Application for a Non-Material Amendment Following a Grant of Planning Permission

Land Off Main Street Norton Disney

Residential development of 2 no. dwellings

21/1777/FUL

**Drawing Number**  
 J1601d-PL-11

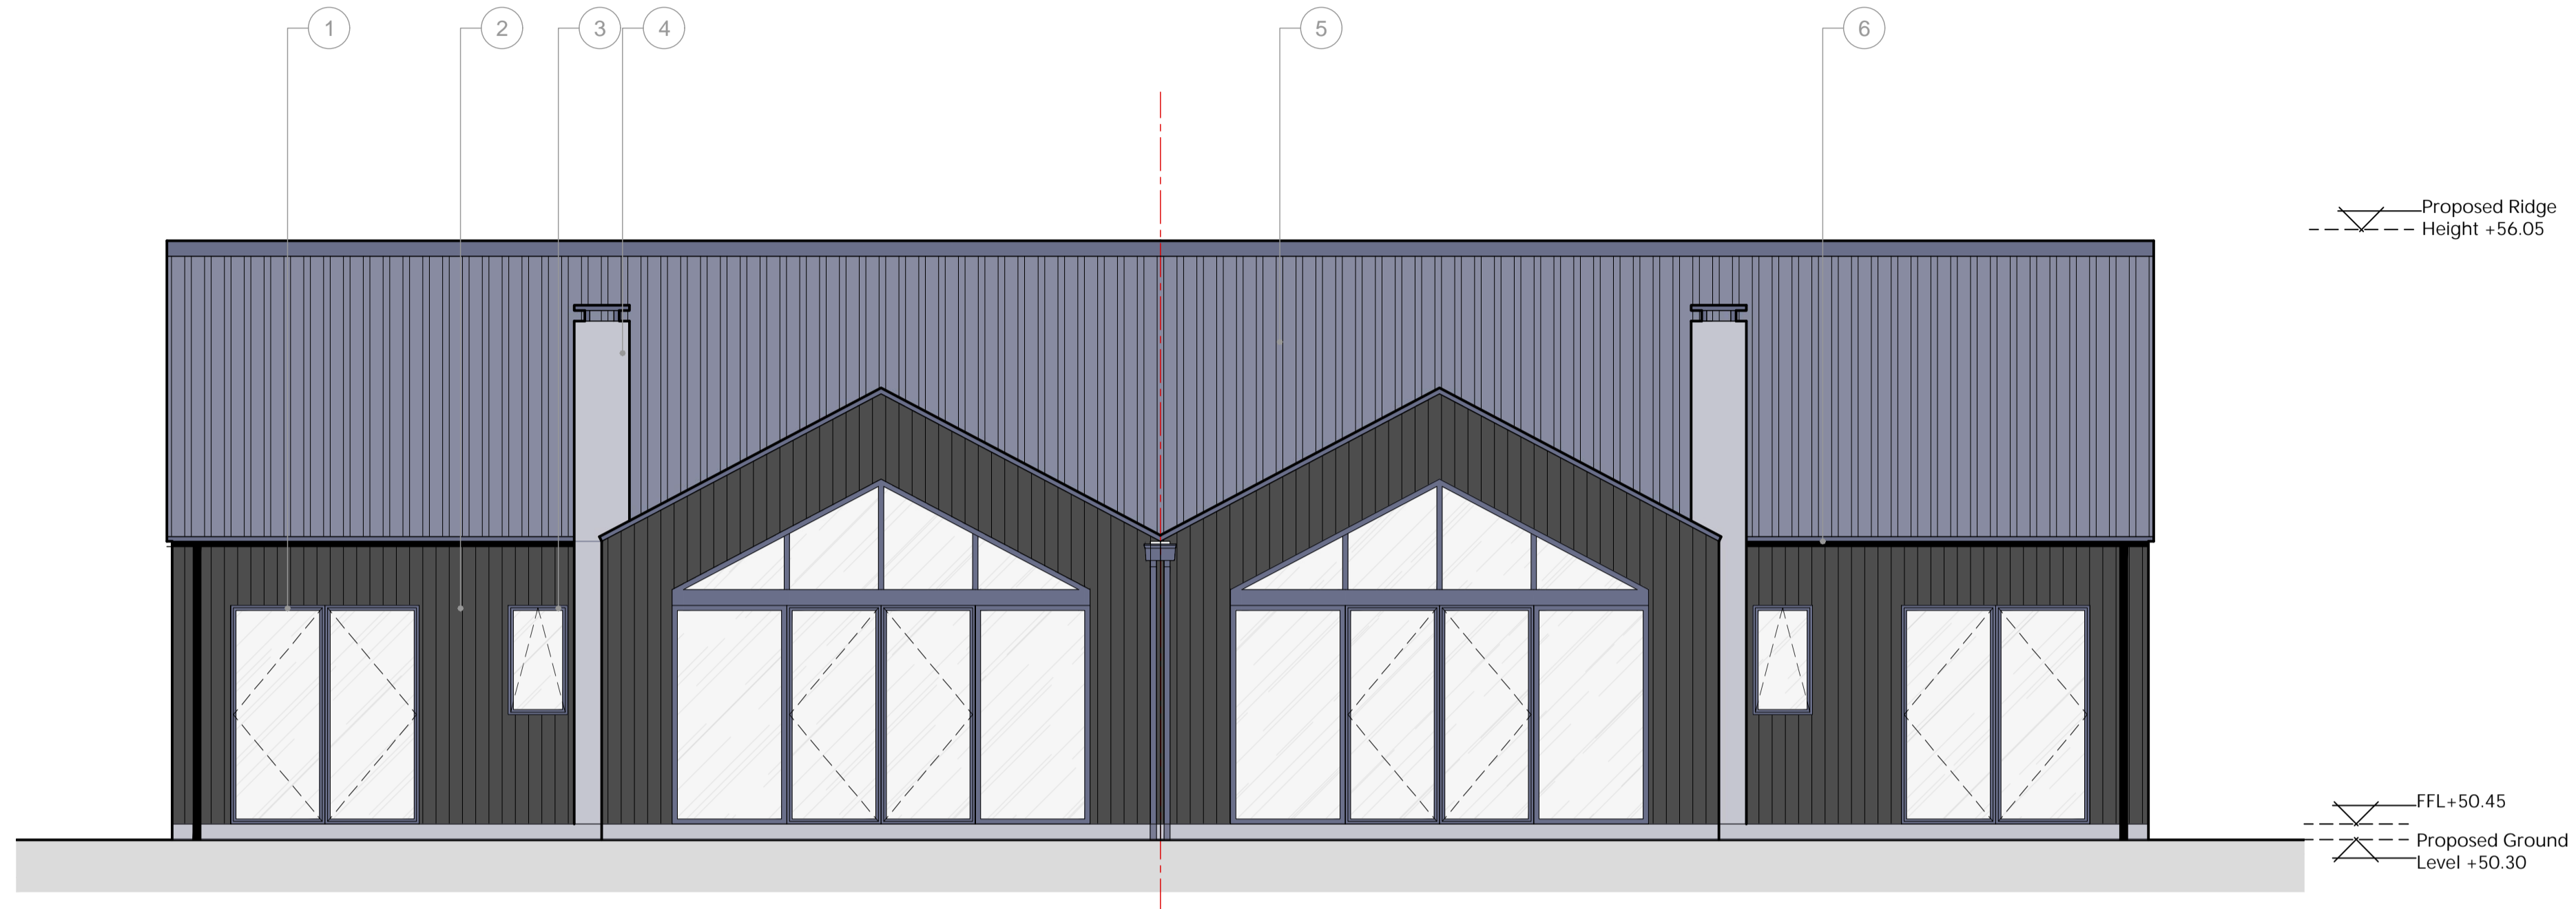
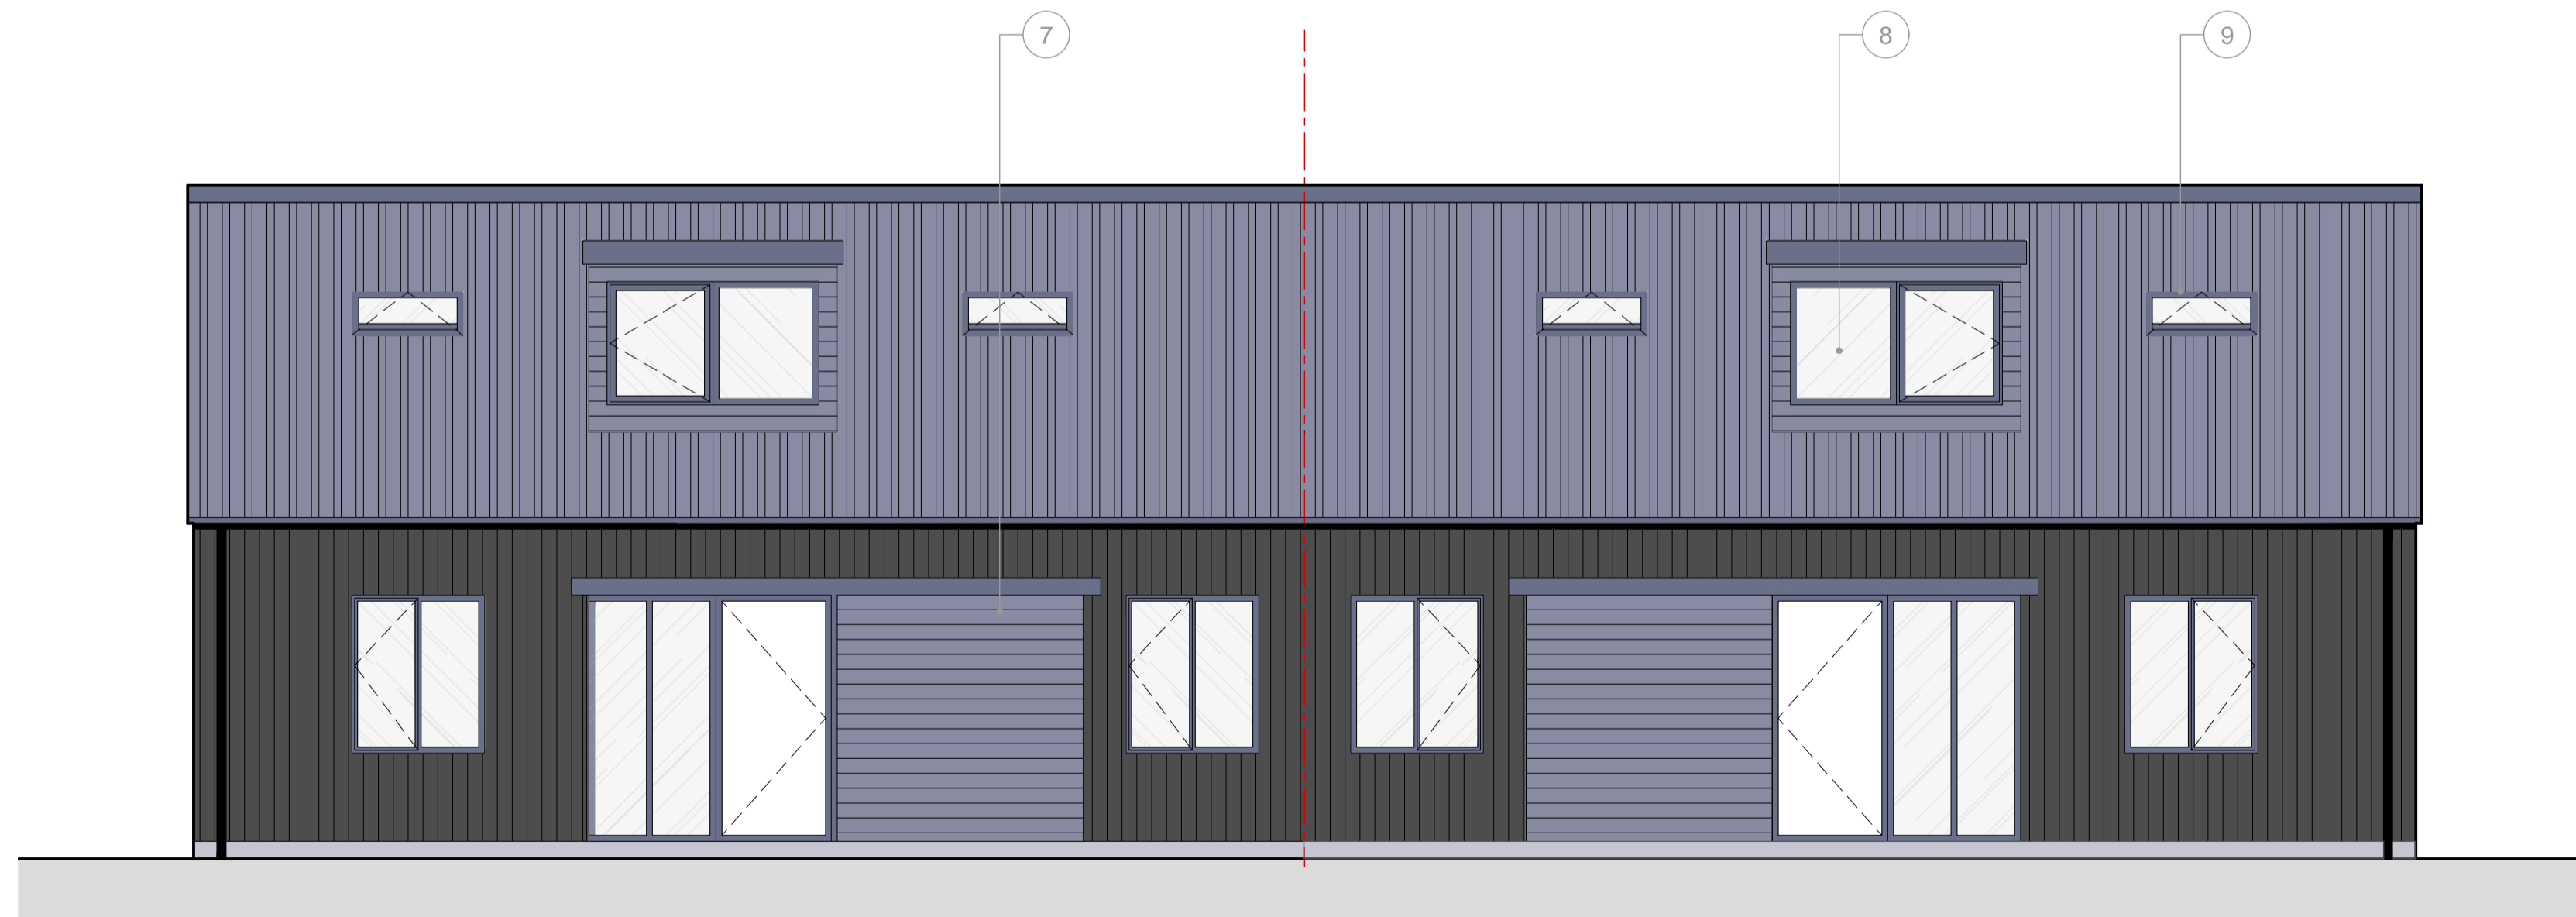
Correction of level labels on elevations to match the levels the drawing shows to provide clarity.

Level labels were shown incorrectly on the previous drawings and do not reflect what is drawn.

J1601d-PL-11 P03, J1601d-PL-12 P02

J1601d-PL-11 P04, J1601d-PL-12 P03
